RE: **Lot 2 Block 3 Unit 18, S.A.D. 228**
6612 Cuervo Pl. NW
Grading and Drainage Plan
Engineers Stamp Date 10-28-19 (D10D003B2)

Based upon the information provided in your submittal received 10/28/19, this plan cannot be approved for Grading Permit until the following comments are addressed

DRAINAGE PLAN

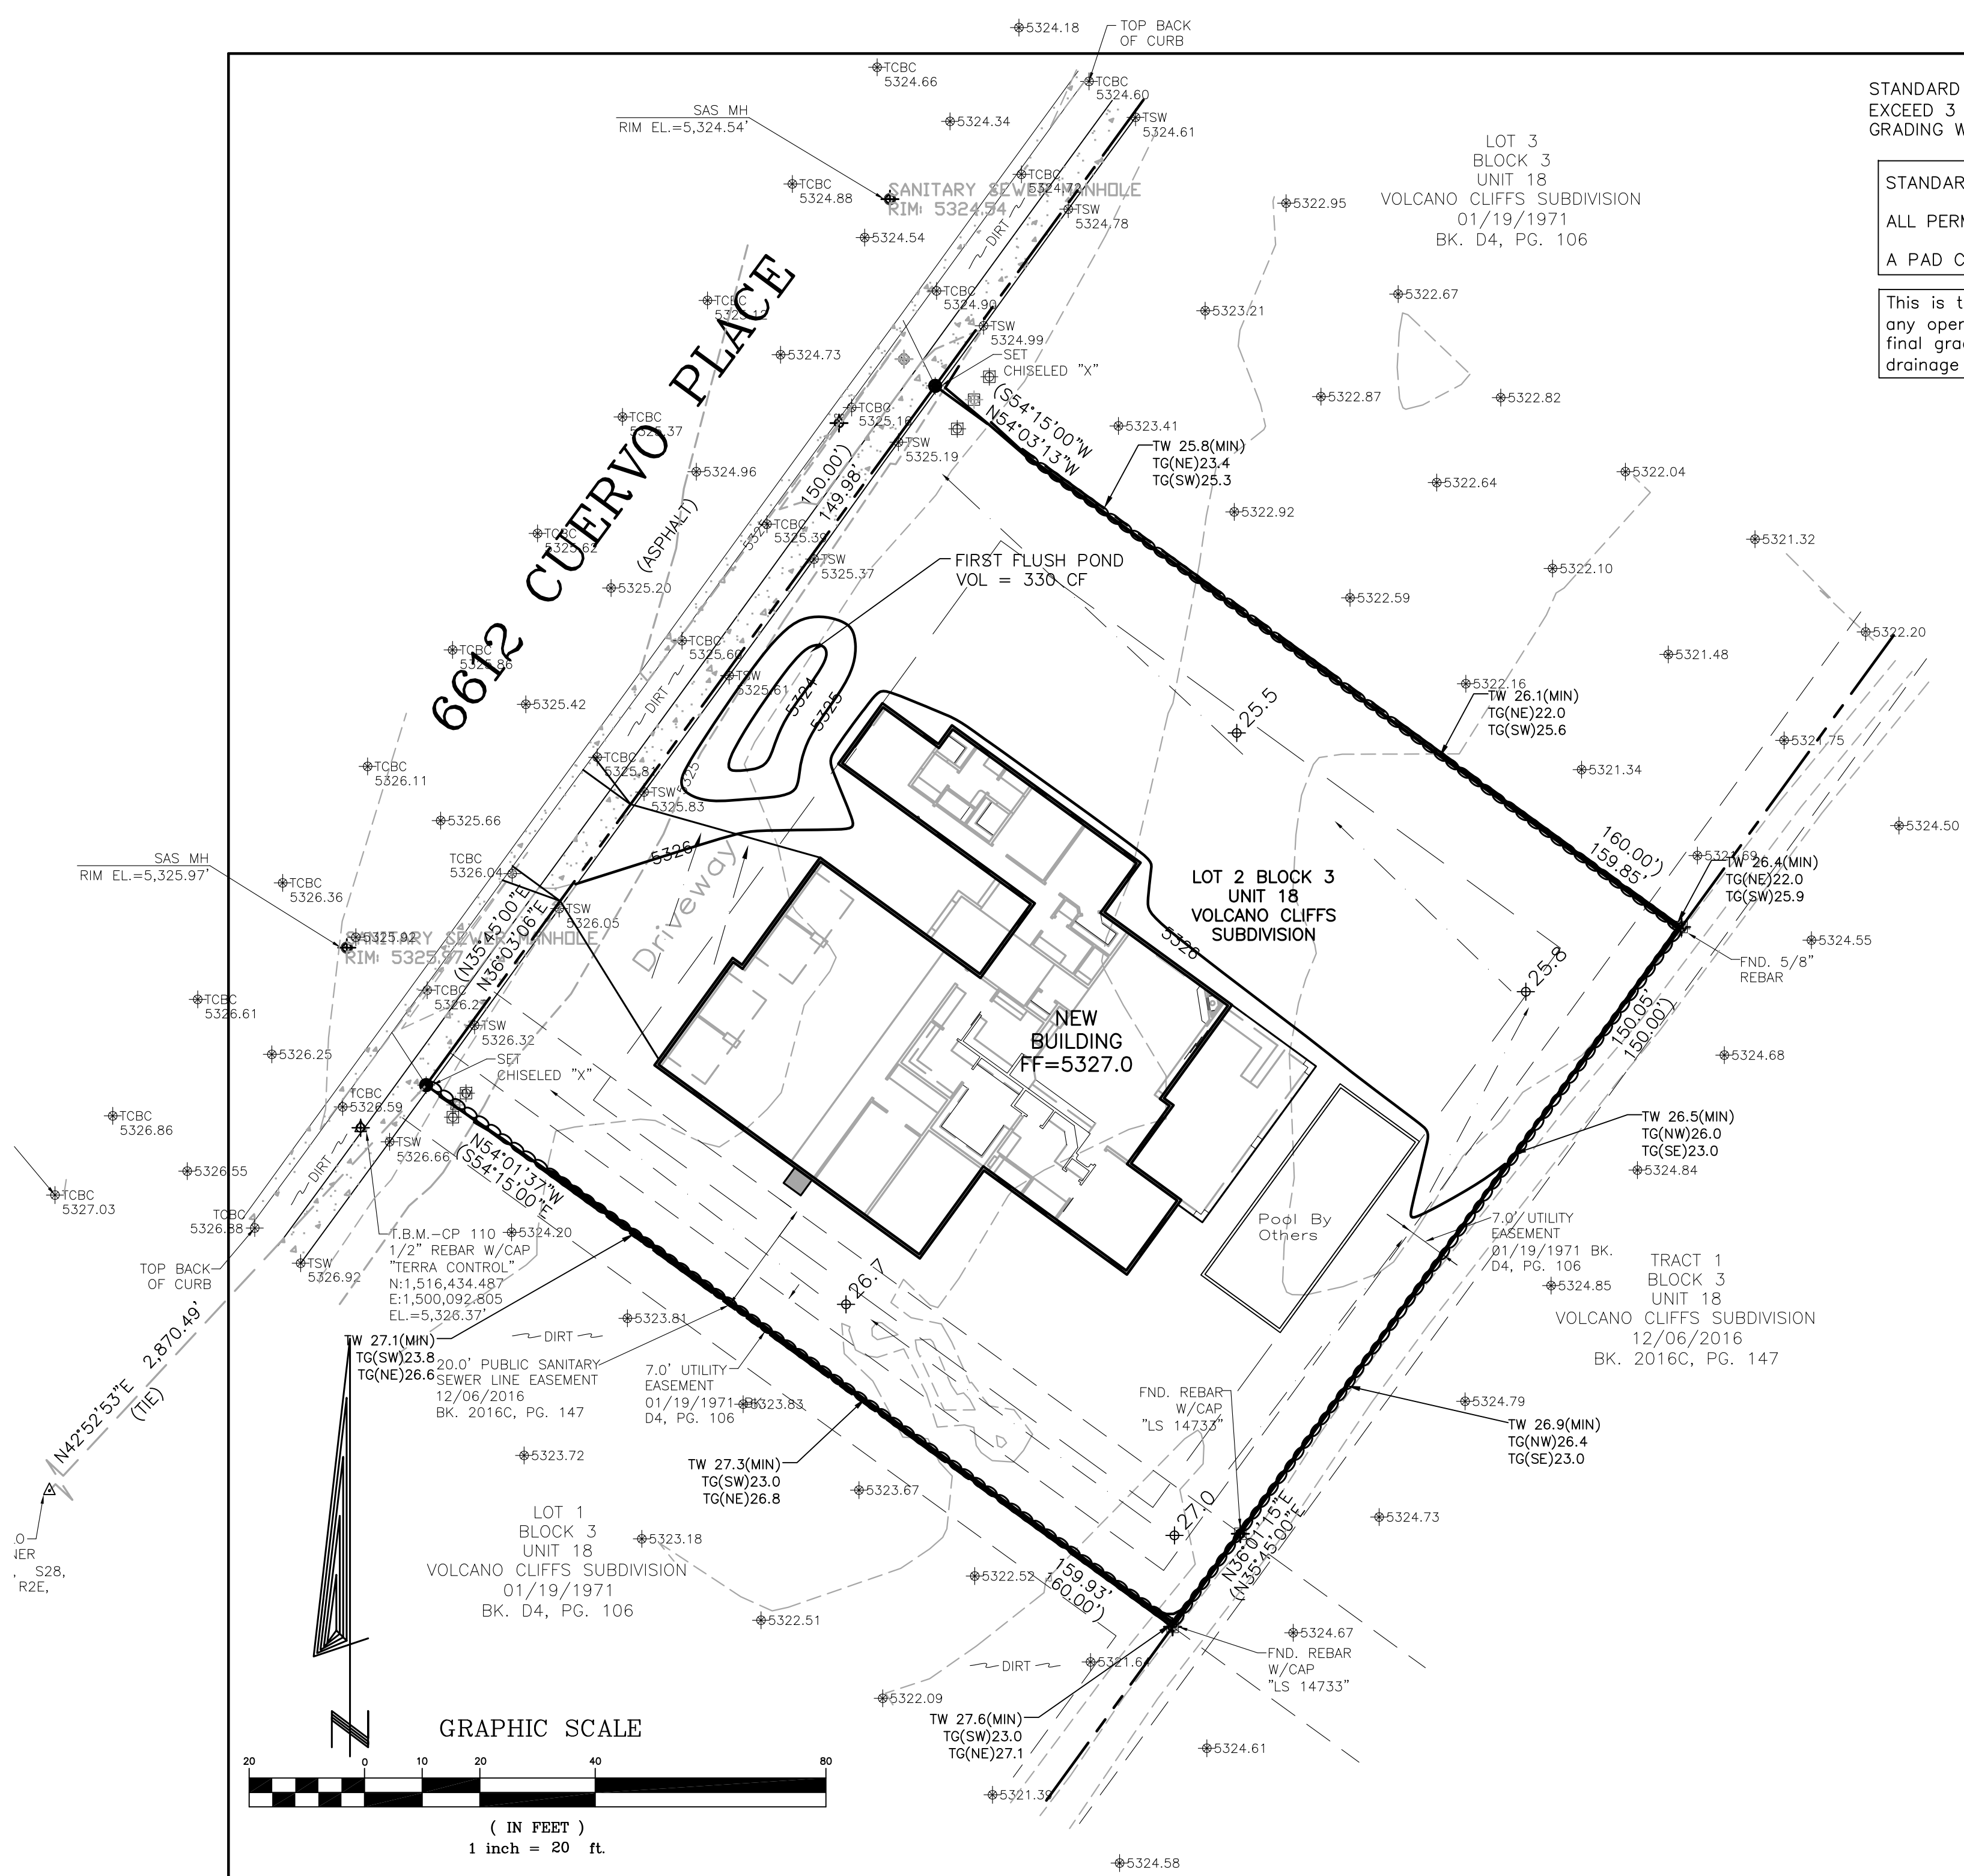
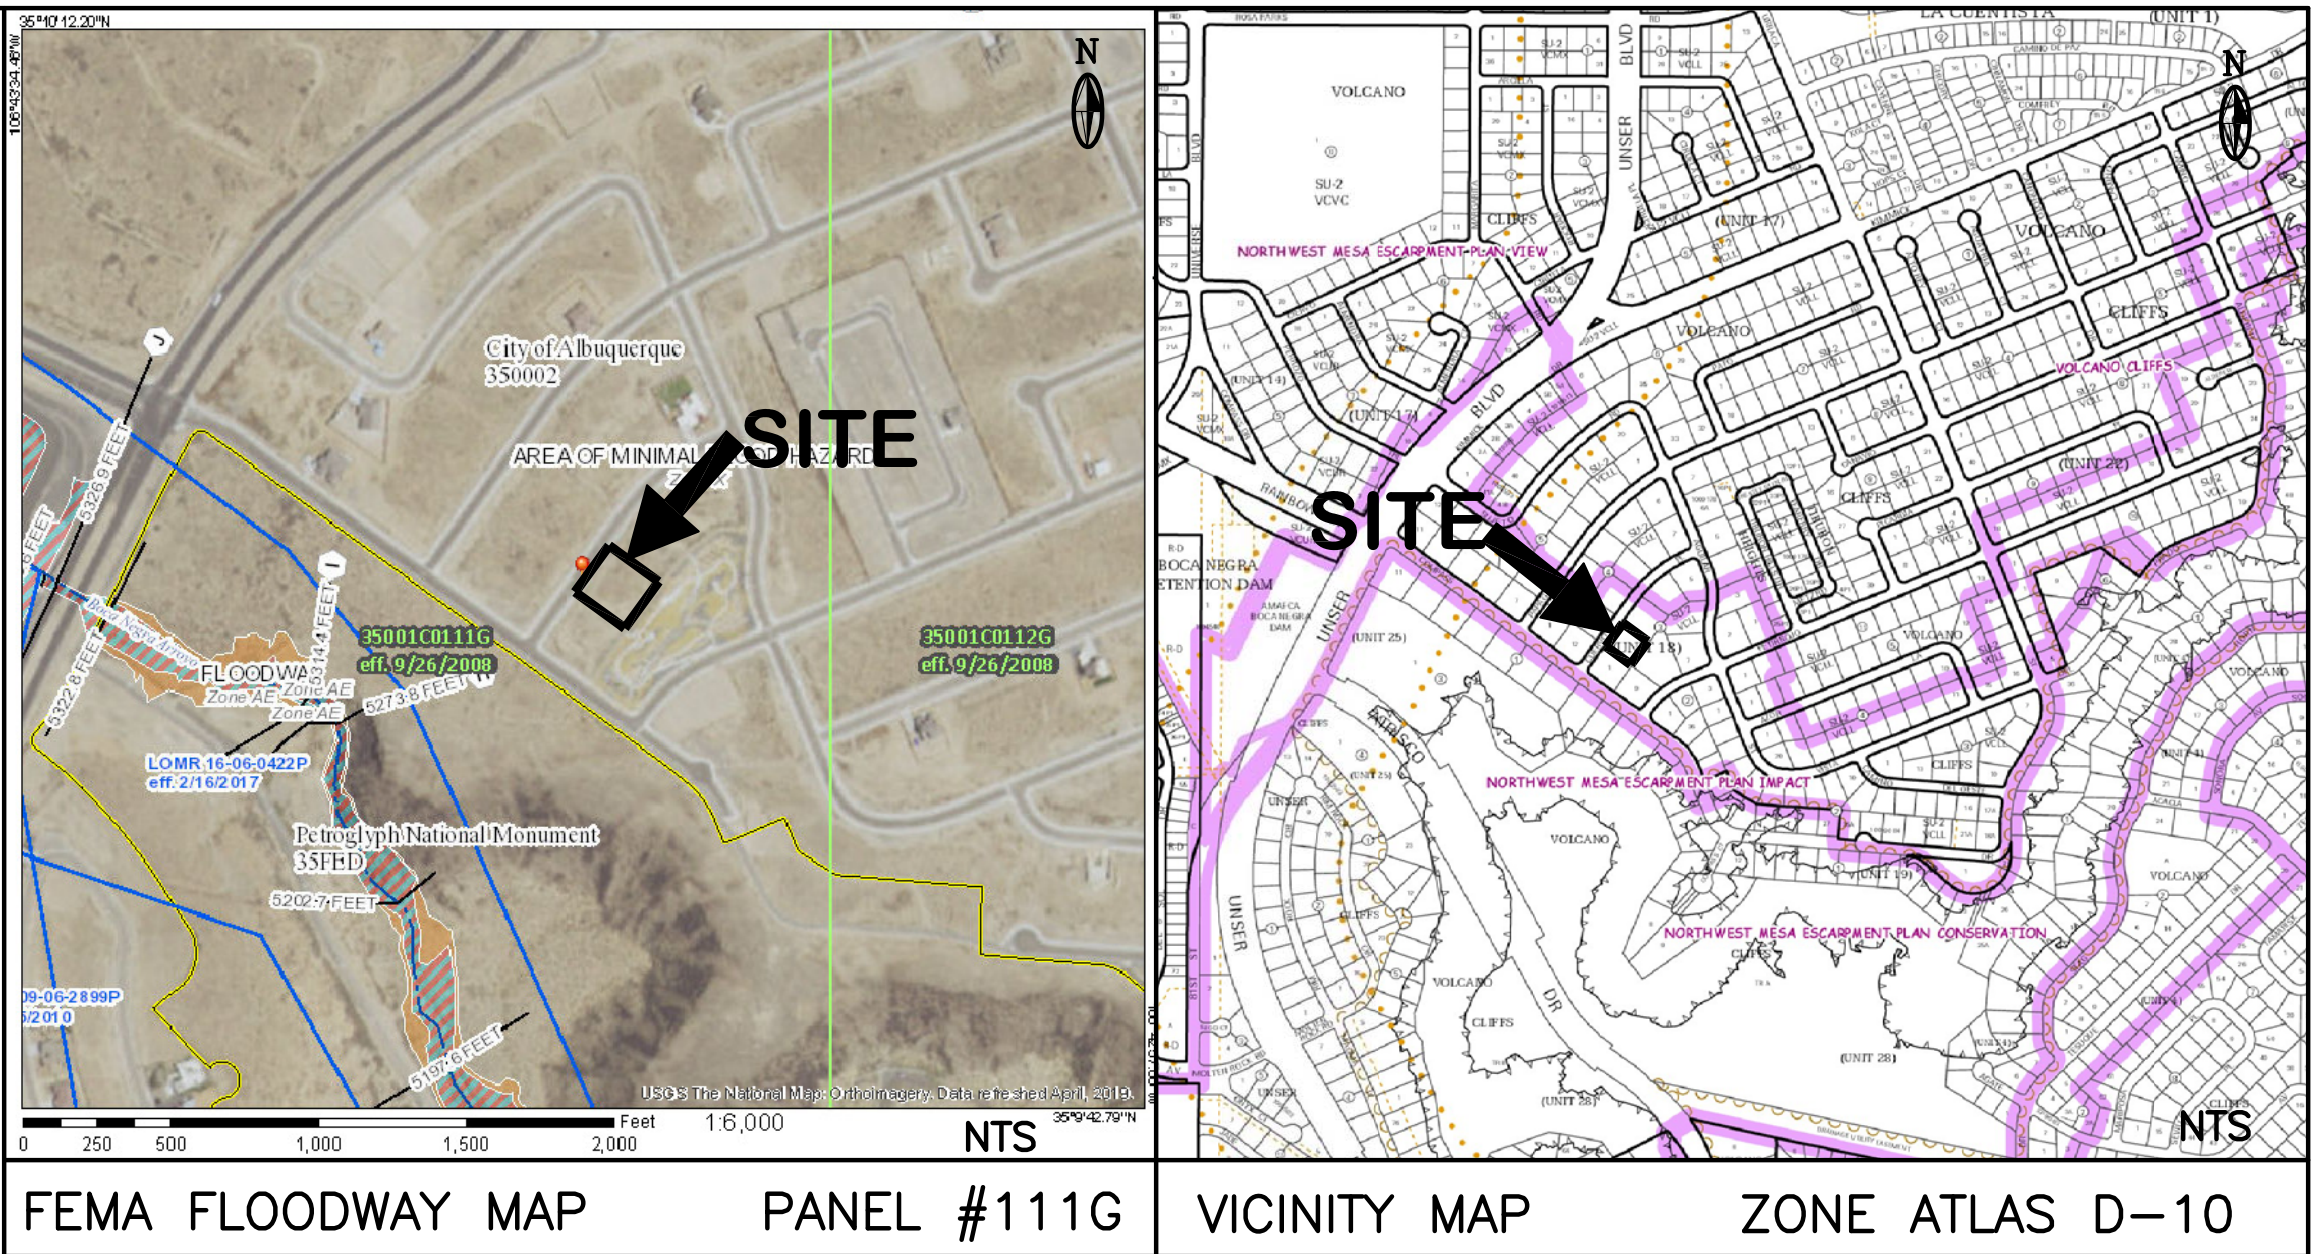
- Provide the amount of treatment C for this lot. Land treatment C is land compacted by human activity, minimal vegetation gravel or rock on landscaping etc.
